March 13, 2023

**RE: Stud Wall Framing in New Garage Construction  
Holly Springs, NC**

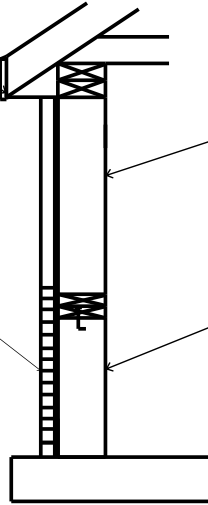
The rear gable end wall may be considered adequate once the following items have been completed:

- Metal strapping connecting king studs across the top plate is currently provided in a few locations. Provide the same metal strapping at each king stud across the top plate and fasten to the king studs above and below the top plate in the same pattern as the currently installed strapping.
- After installation of the strapping is complete, provide 2x6 blocking between studs at 4'-0" above and below the top plate. Cover the interior side of the area bound by the blocking with  $\frac{3}{4}$ " structural panel sheathing, fastening the sheathing to all studs and blocking at 6" o.c.

The front gable end wall, with the garage door openings, may be considered adequate once the following items have been completed:

- Metal strapping is to be installed at each door per Figure R602.10.1 of the 2018 NC Residential Code.
- After installation of the strapping is complete, provide 2x6 blocking 4'-0" above the top plate. Cover the interior side of the wall from this blocking all the way down to the foundation wall with  $\frac{3}{4}$ " structural panel sheathing in accordance with Figure R602.10.1 of the 2018 NC Residential Code.
